28 January 2018

Alexandria Park Community School Redevelopment, Park Road, Alexandria (SSD 8373) submission

AR.DA. 5001 P1

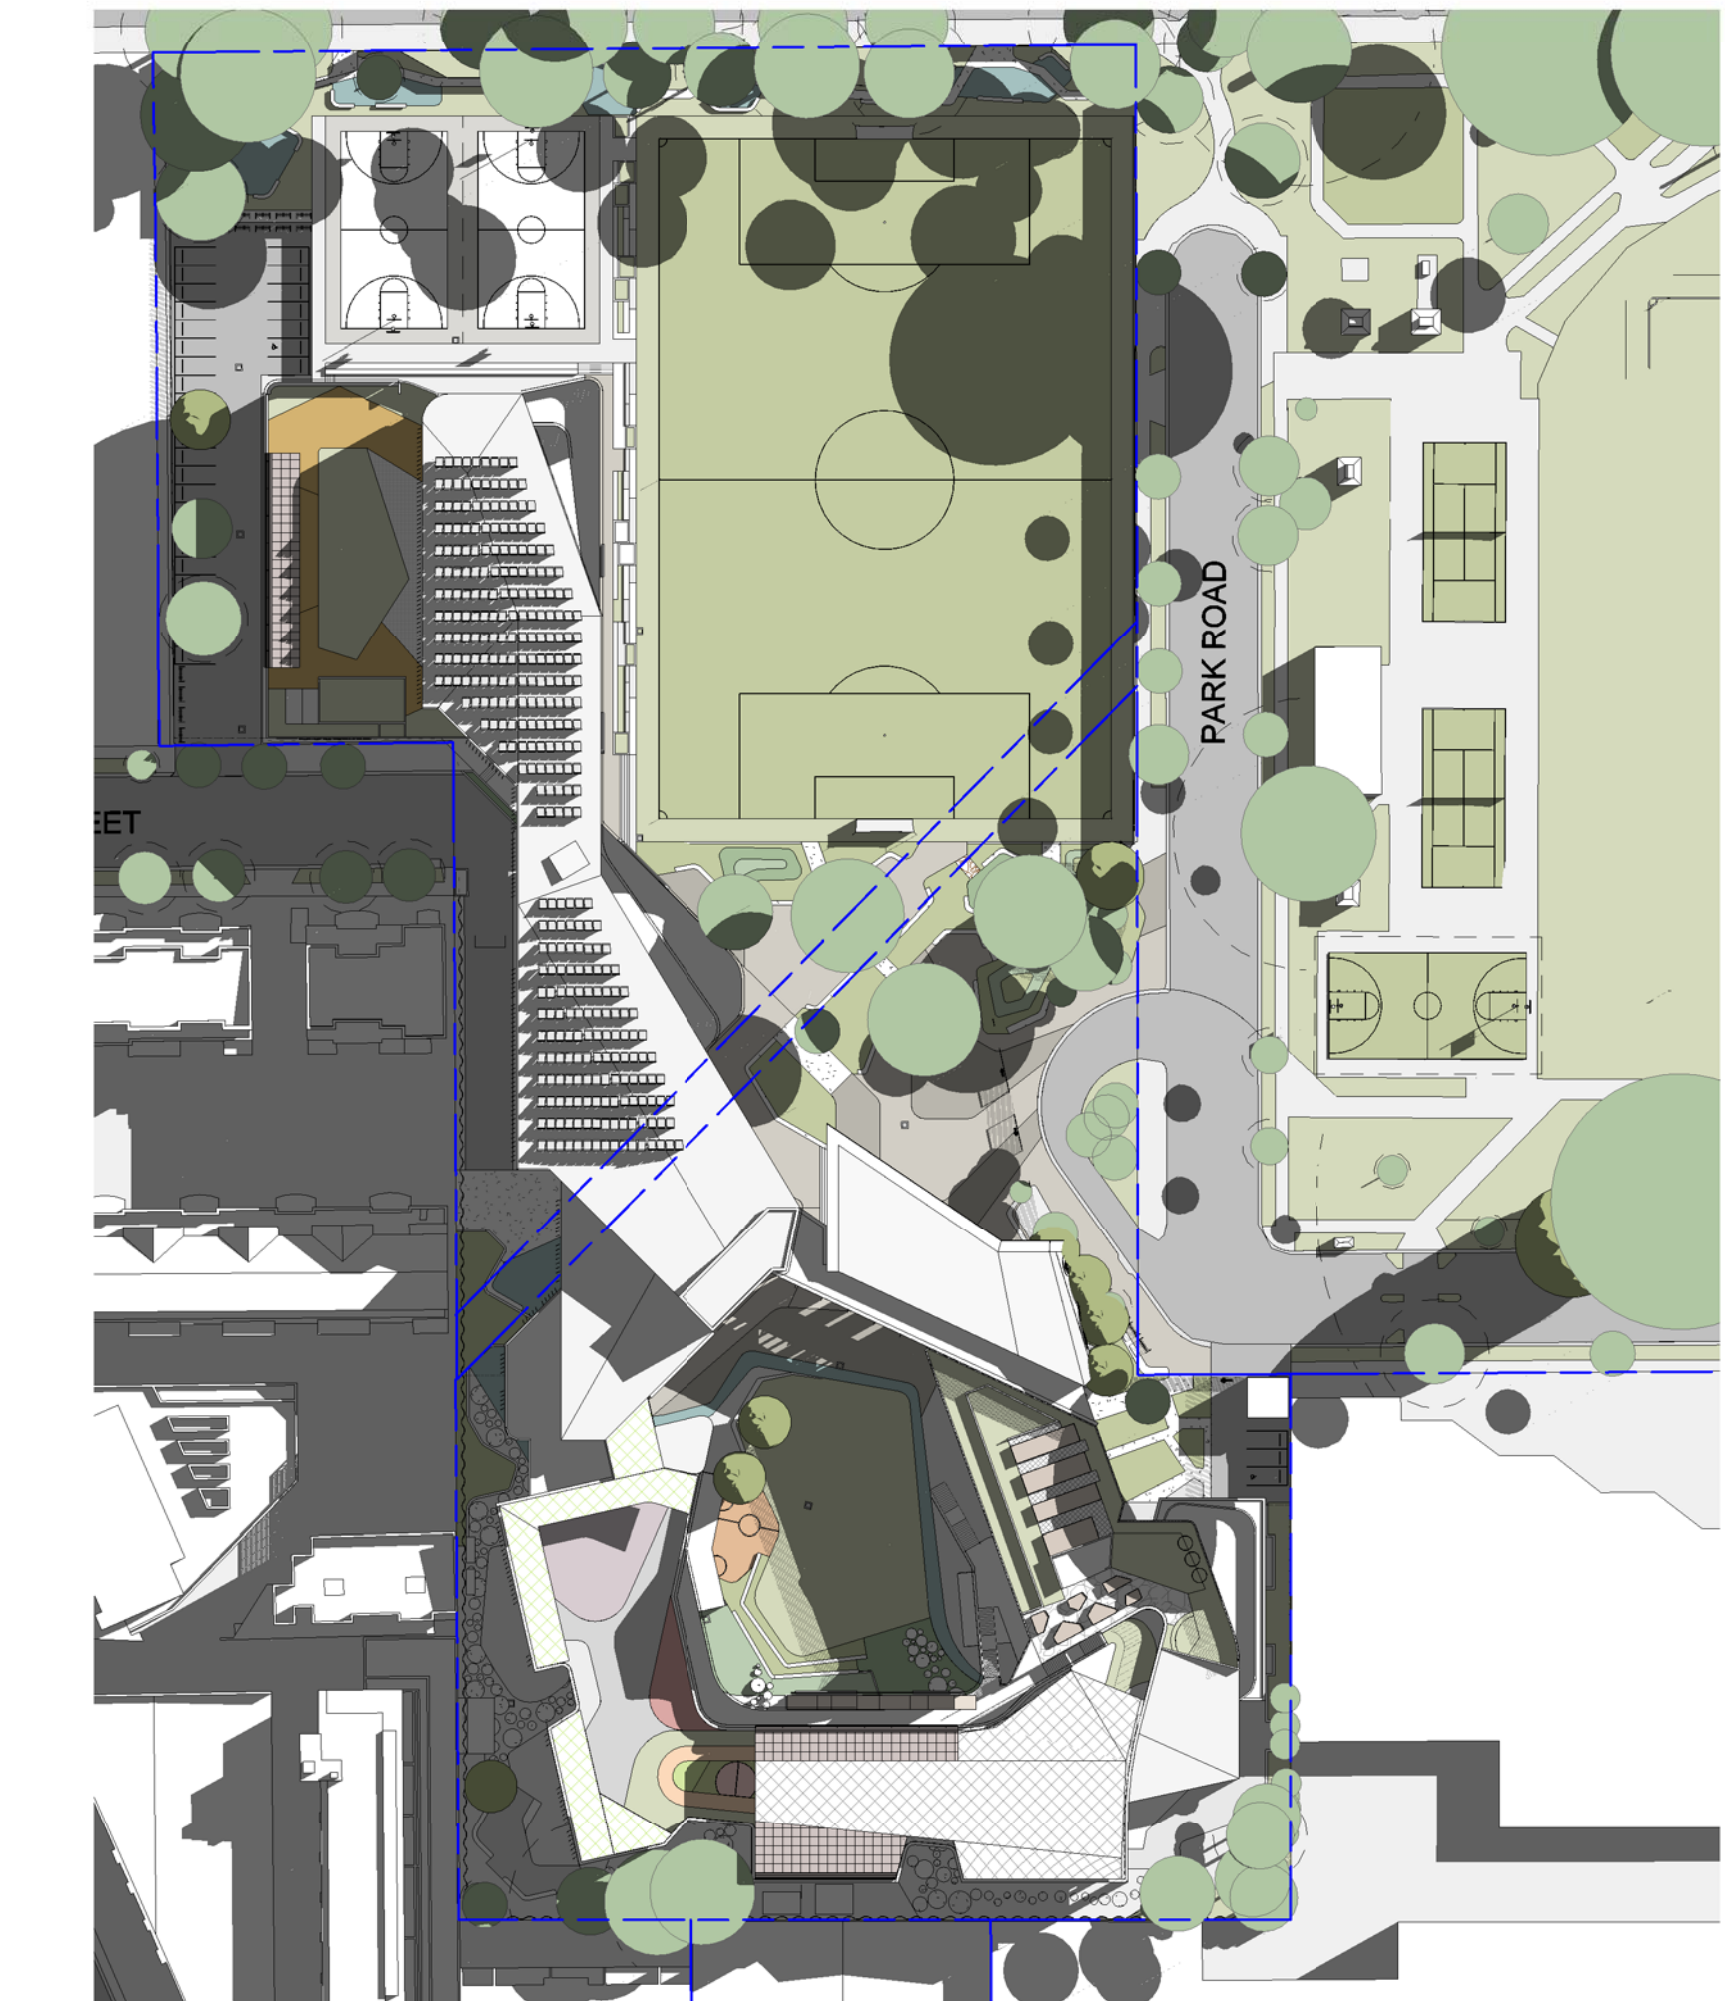
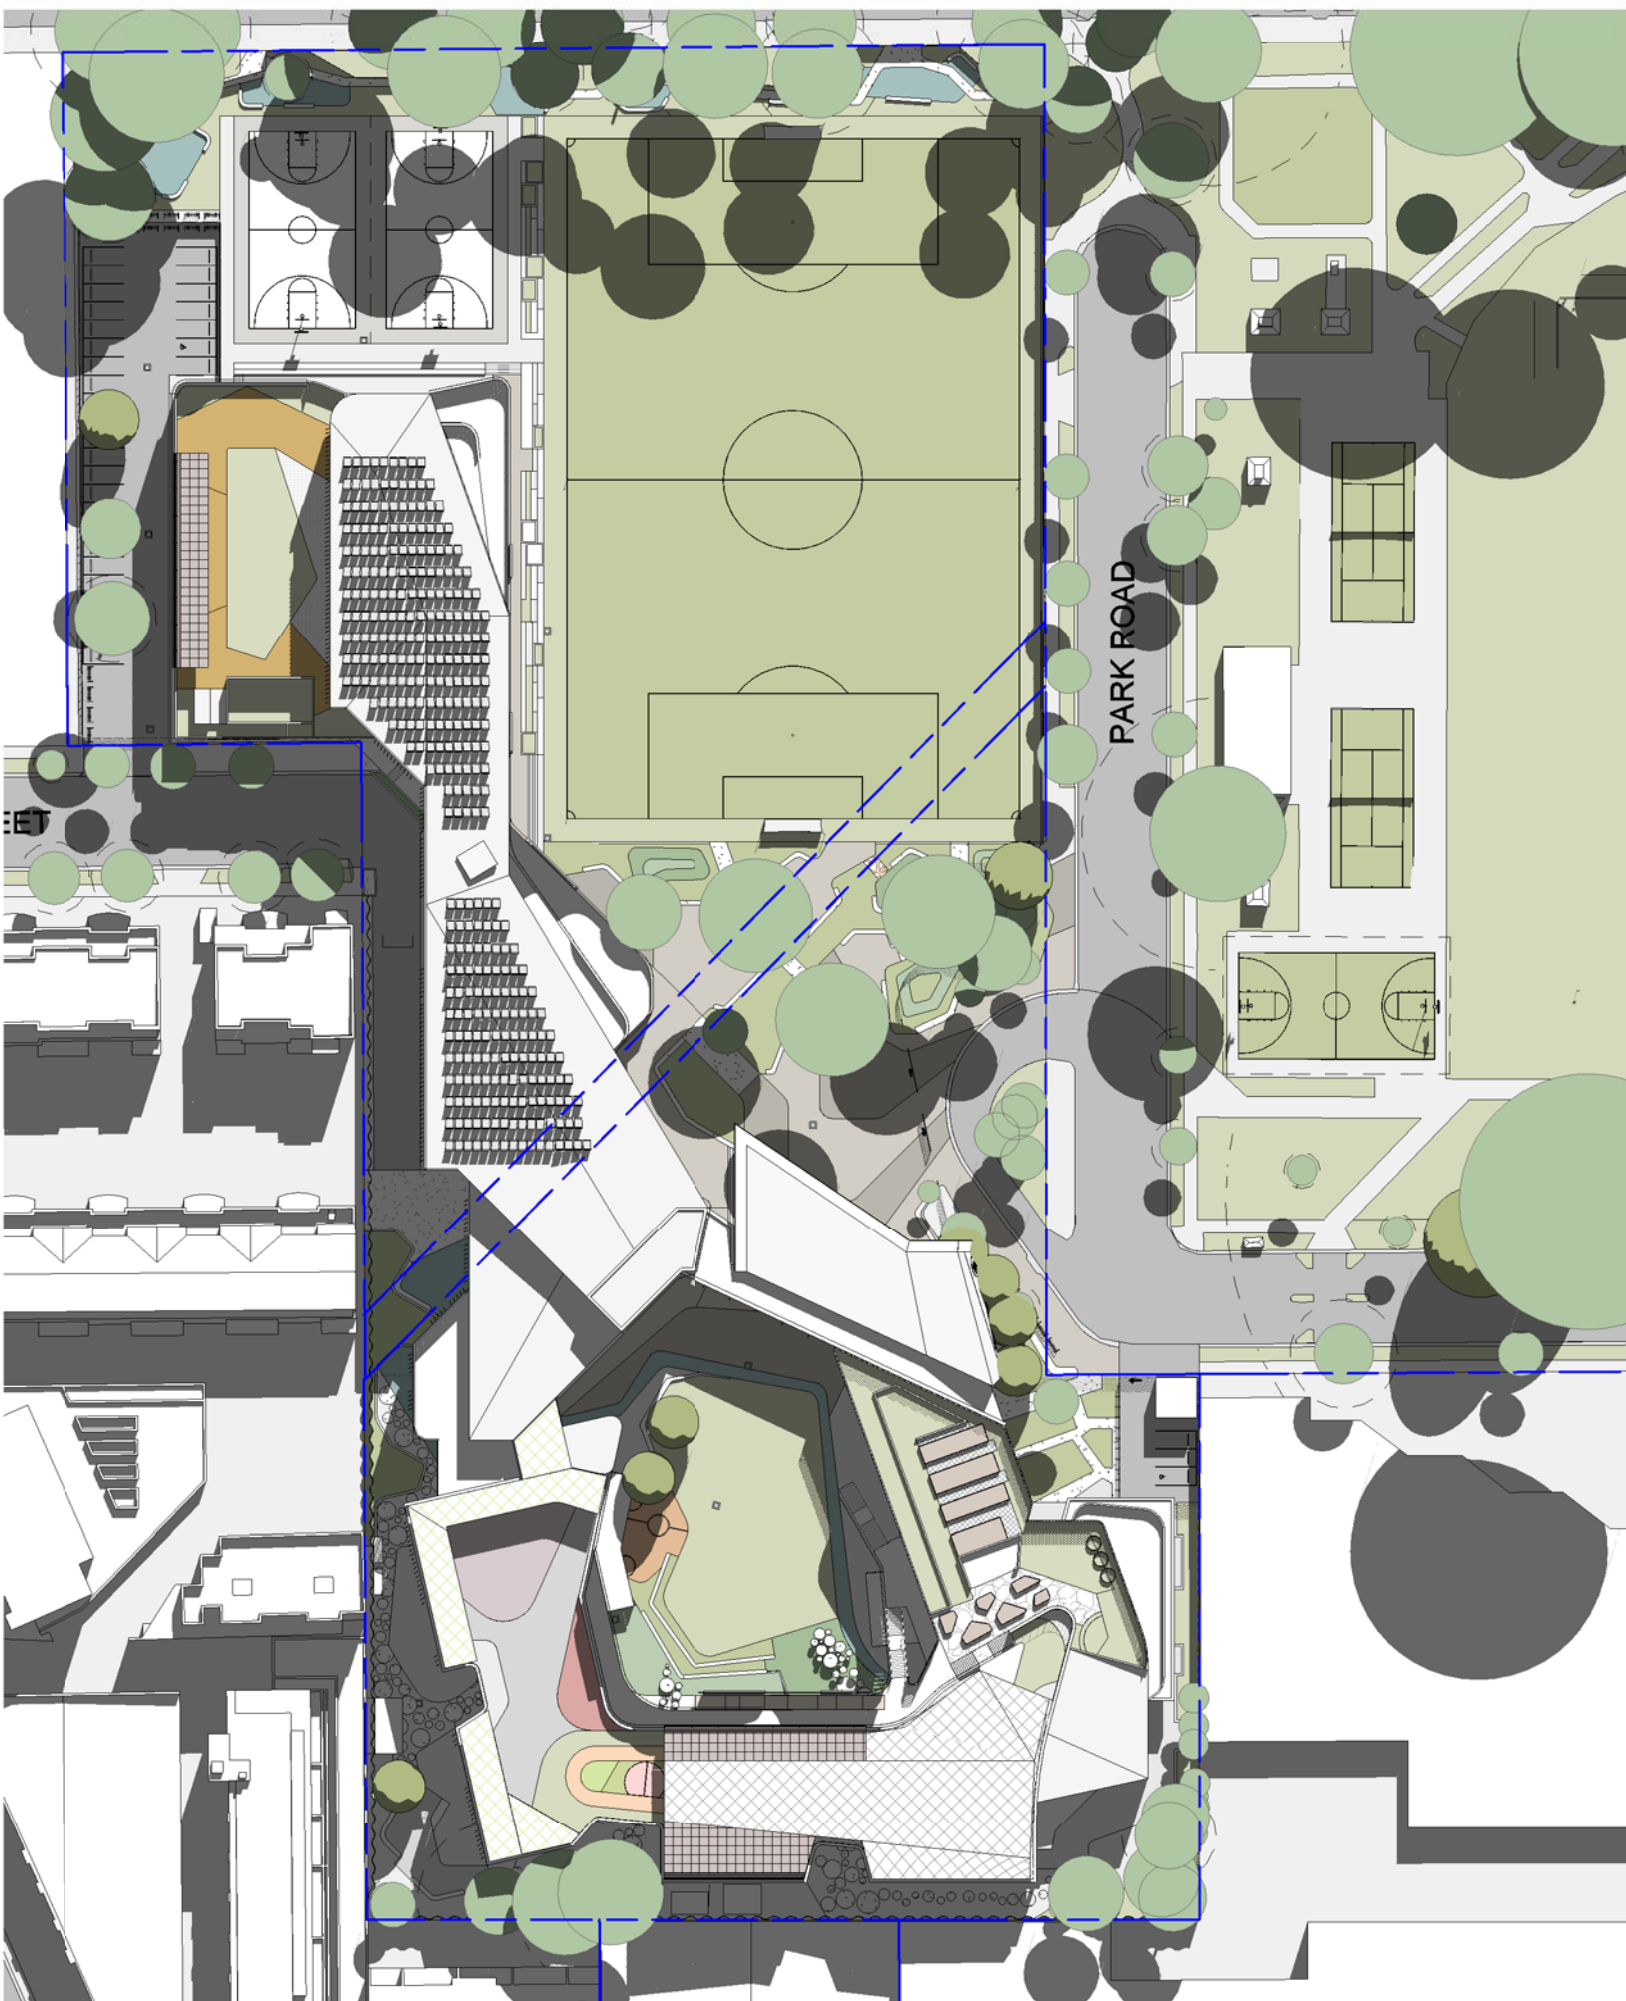
We are extremely concerned at the solar overshadowing the proposed 5 storey, 21 metre building will cause to our ground floor garden apartment Lot 10 of 44-58 Belmont Street, on the Western side of the school. From the shadow diagrams provided, our primary living area, dining room kitchen and front garden courtyard will lose approximately 50% or 4 hours of full sun light on the winter equinox from sunrise at 7.00am until approximately 11.00am. Our apartment again will lose sun due to overshadowing by existing buildings to the north of our apartment sometime mid afternoon. It is unclear how many hours of direct solar access we will have left if the proposed school building is built. Due to the design of our apartment, having only two points of solar access, a front sliding door facing north and a back door facing south, with no other windows on either the east or west of the apartment, we are heavily reliant on good solar access for light and warmth and wellbeing from these points. If hourly solar overshadowing diagrams could be provided as required they would assist to clarify the extent of overshadowing.

We respectfully suggest that consideration be given to exploring opportunities to reduce the extent of solar overshadowing on neighbouring residences on the western boundary of the school. A combination of the following may be considered:

- Reducing the height of buildings which will overshadow neighbours on the western boundary to the current 15 m height limit for this site;
- Terracing the western facing upper floors back from the western boundary; and/or
- Moving buildings on the western boundary further away from neighbouring residences.
